KITTITAS COUNTY DEPARTMENT OF PUBLIC WORKS

MEMORANDUM

TO: Community Development Services
FROM: Taylor Gustafson, Environmental/Transportation Planner
DATE: December 28, 2018
SUBJECT: Granite Creek BL-18-00012

RECORD OF SURVEY
 A PTN OF THE E 1/2 OF THE SW 1/4 & A PTN OF THE W 1/2 OF THE SE 1/4 OF SECTION 3,
 TOWNSHIP 19 NORTH, RANGE 14 EAST, W.M.,
 KITTITAS COUNTY, WASHINGTON

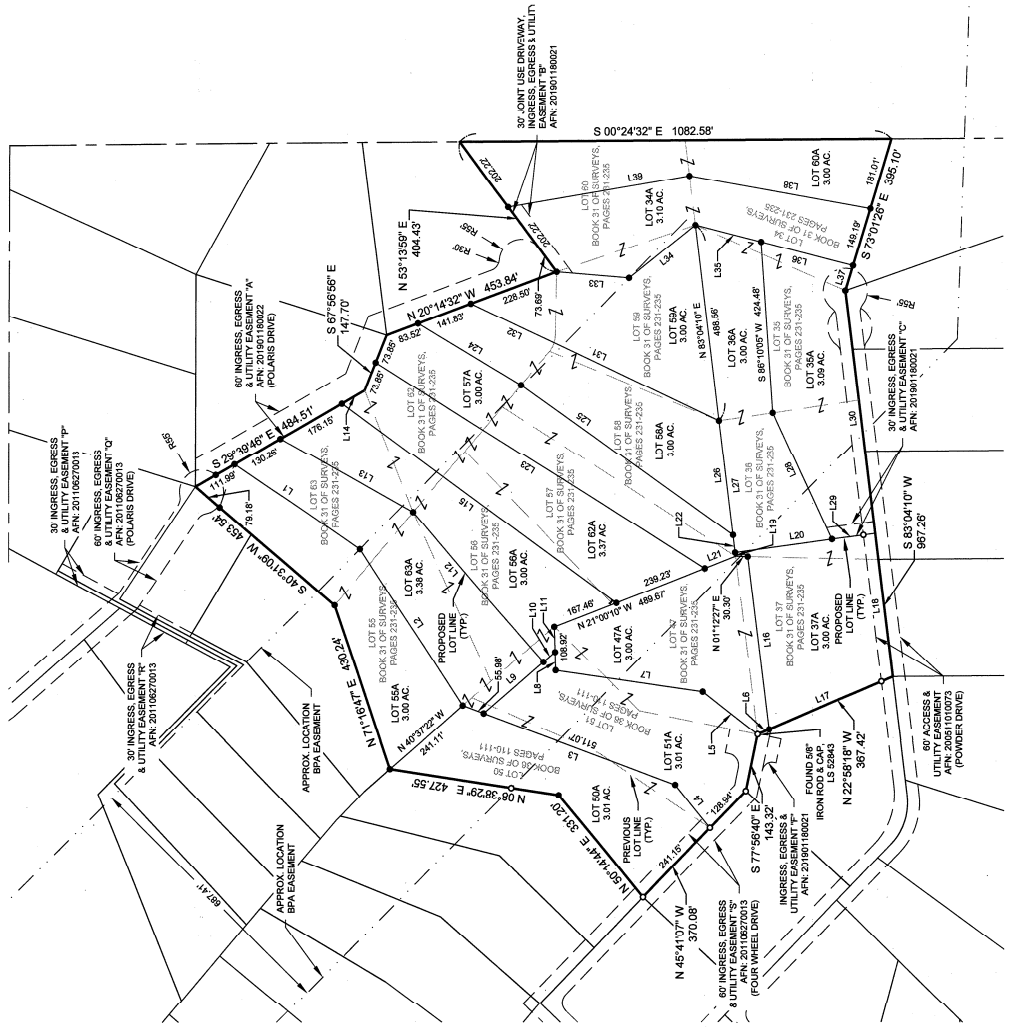
1. Road standards may vary depending on the access location for the new buildable lots 55A, 63A, 56A, 62A, 57A, 58A and 59A of the review draft record of survey dated 12/2018. The applicant shall work with Public Works to establish the access in which these properties will be served from to determine the private road standards that will apply. All private roads must be constructed and certified to meet the current 2015 private road standards prior to final approval.

4. All easements are to be labeled with recording numbers.
 - a. Joint use easement between lot 51A and 47A needs to be labeled.
5. Fire Apparatus turn arounds required on all roadways with appropriate turning radius per the International Fire Code Appendix D.

1. The West boundary of Lot 50A has lines crossing text (331.20') that may become difficult to read after scanning.
2. The West boundary of Lot 55A has lines crossing text (S40-31-09W 453.54') that may become difficult to read after scanning.

3. The South line of Lot 59A is missing a bearing.
4. The area near line "L19" is crowded and difficult to determine.
5. The Surveyors Certificate is missing.

6. All existing easements should include references to the record documents. In the case of the BPA easement, a note stating that the easement as shown is approximate and based upon the following AFN's:.....

7. Ensure that the separate document used to create the access easement for lots 47A and 51A provides a suitable description to delineate the easement, OR add suitable line labels to the face of the map to do the same.

8. There appears to be a double cul-de-sac near the Southeast corner of Lot 35A.
